Case ref: EN010168  
Date: 17 October 2025

### **Application by Lime Down Solar Park Limited for an order granting development consent for the Lime Down Solar Project**

#### **Advice following issue of decision to accept the application for examination**

Title:
Figure 11-3.1: Lime Down C1 Fluvial Flood Risk Map

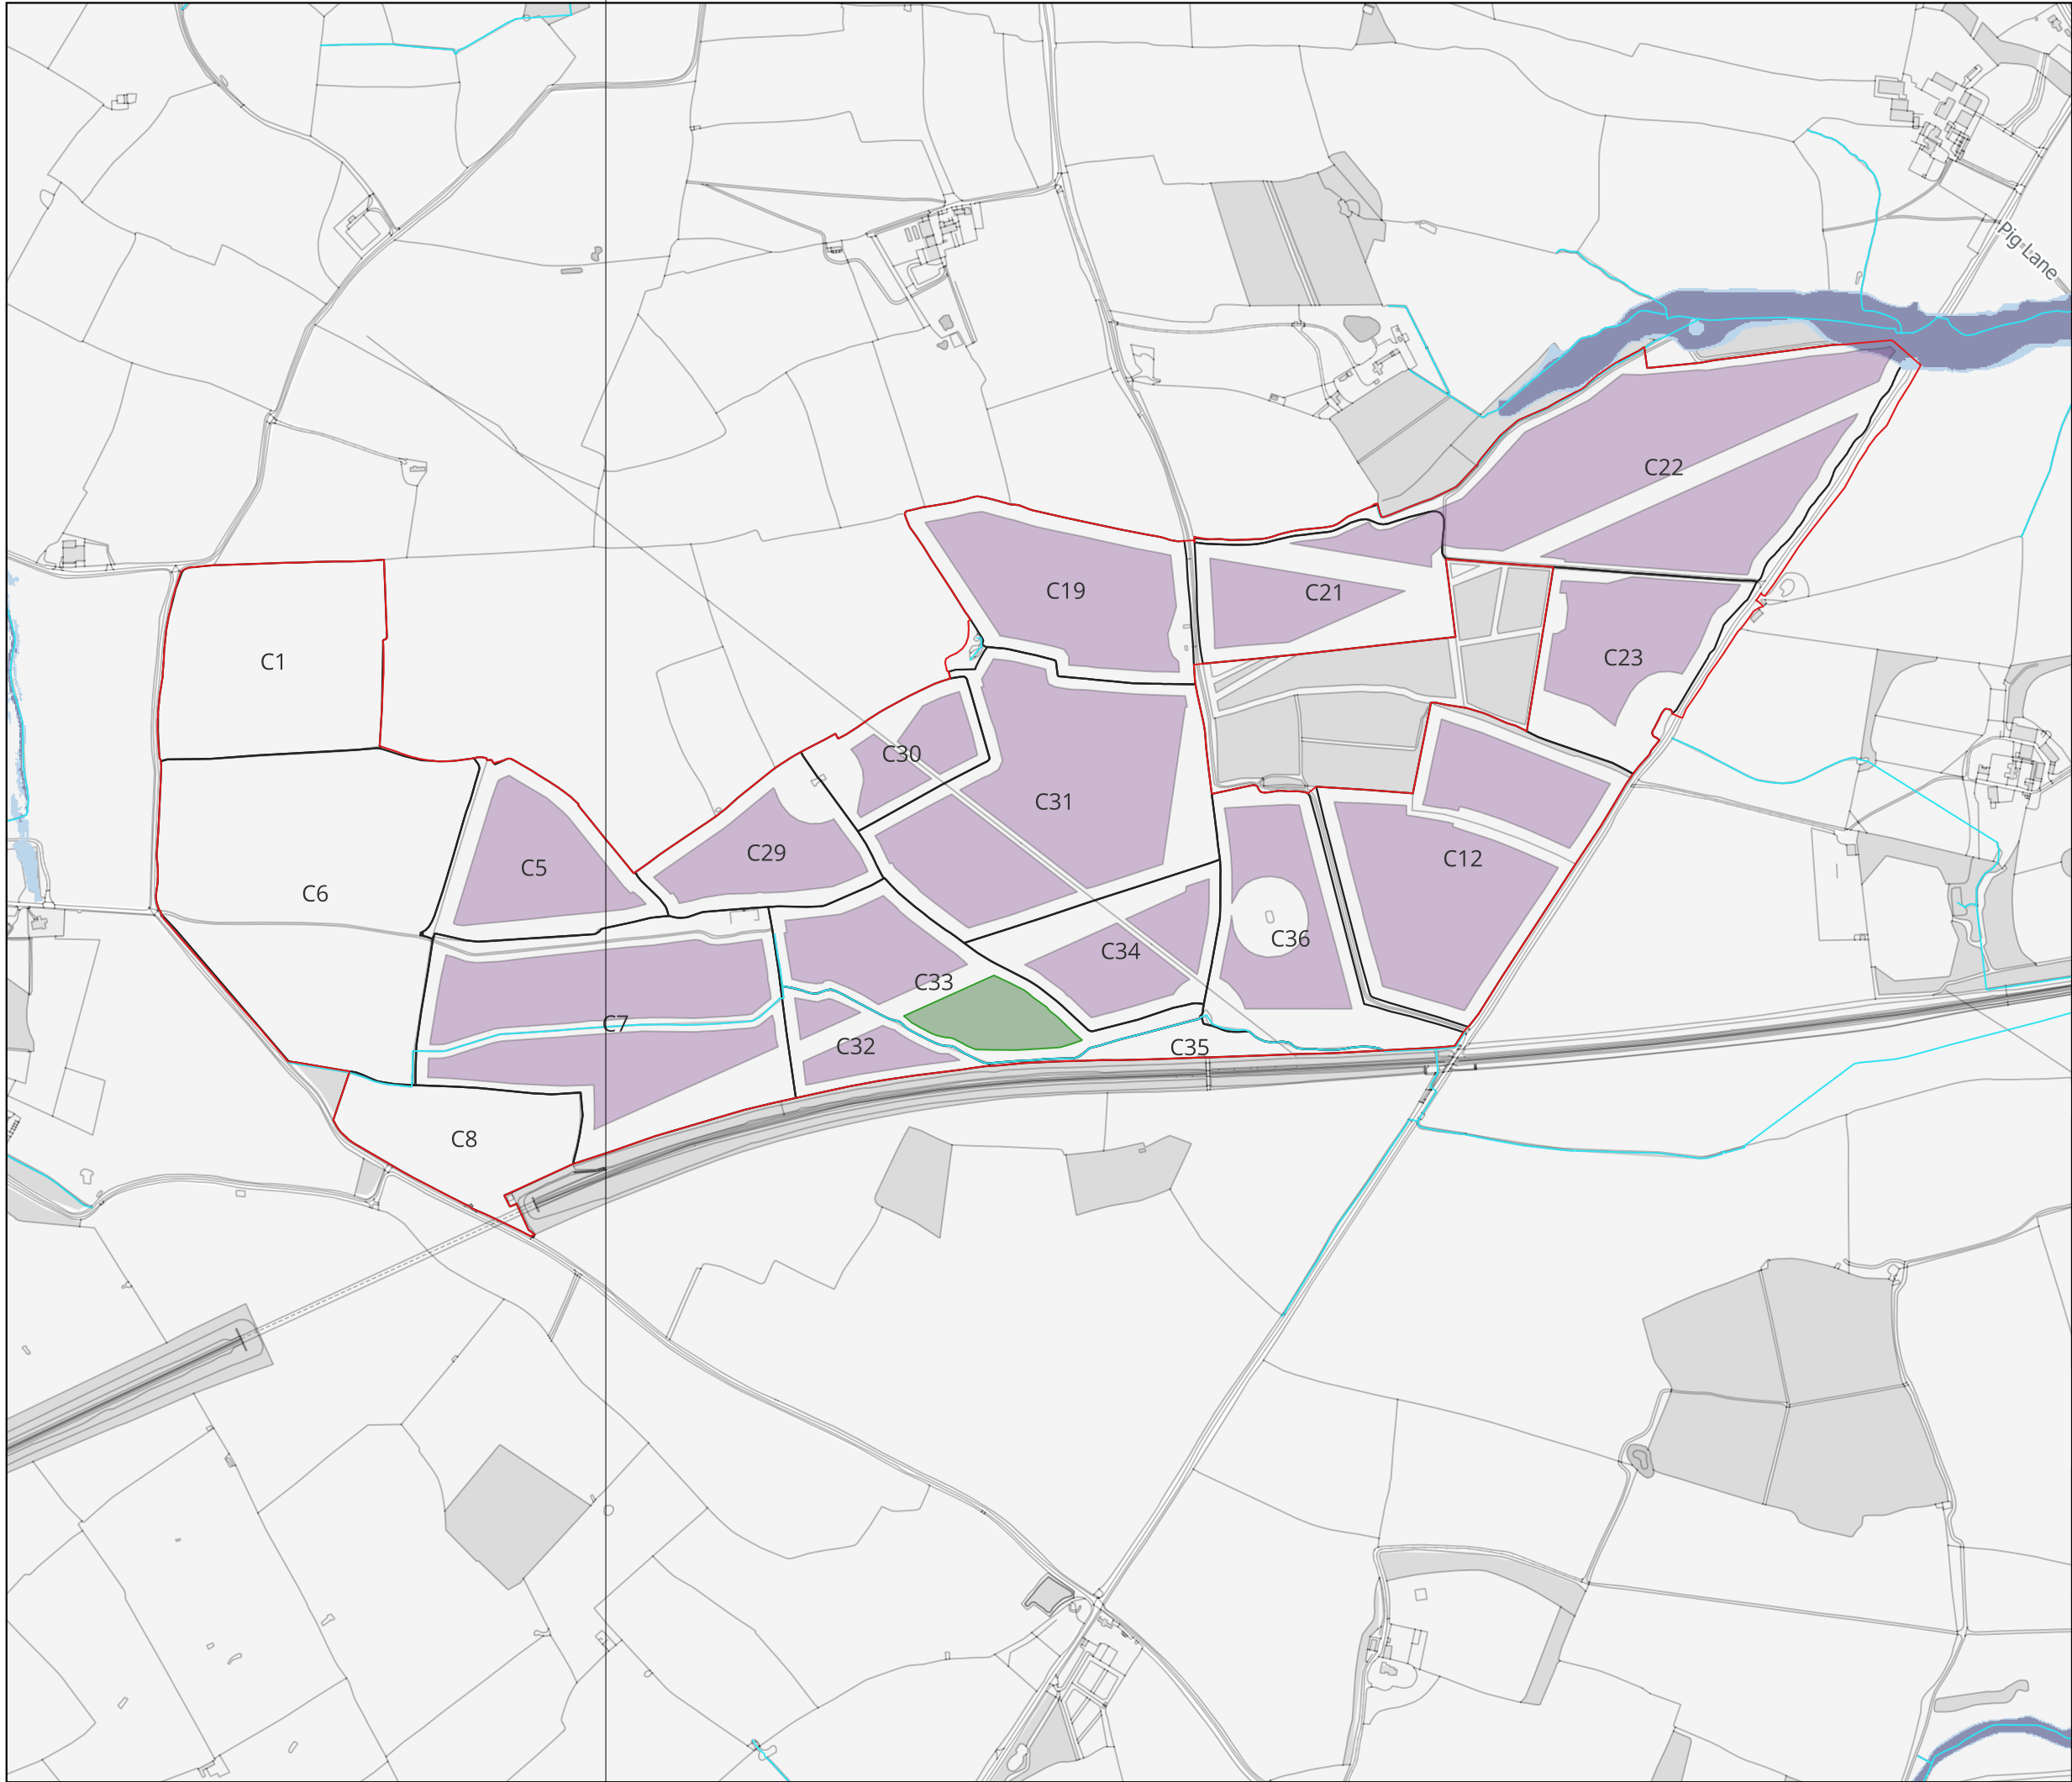
The Flood Risk Assessment (FRA) and Drainage Strategy (ES Appendix 11-1 to 11-9) does not differentiate between Flood Zones 3a and 3b. The FRA should clarify which of these flood zones the relevant parts of the site fall into and display this on a figure.

The FRA and Drainage Strategy (ES Appendix 11-1 to 11-9) provide sections setting out the site conditions and locations of waterbodies in the area. Figures have been provided displaying watercourses and bodies for each of the 'sites'. The names of watercourses and bodies have not been labelled on all these figures although where relevant, the location has been described in the text. The FRA should provide appropriate figures displaying labels for all named watercourses and bodies.

It would assist the Inspectorate if the applicant could name the document files with relevant details to allow for a smoother, and swifter publication process. Eg instead of '6.2 Figure 11-3 Lime Down C1 Flood Risk Map', could you consider adding that Figure 11-3 is part of the Environmental Statement and the volume number. For example, '6.2 ES, Volume 2, Figure 11-3 Lime Down C1 Flood Risk Map'.
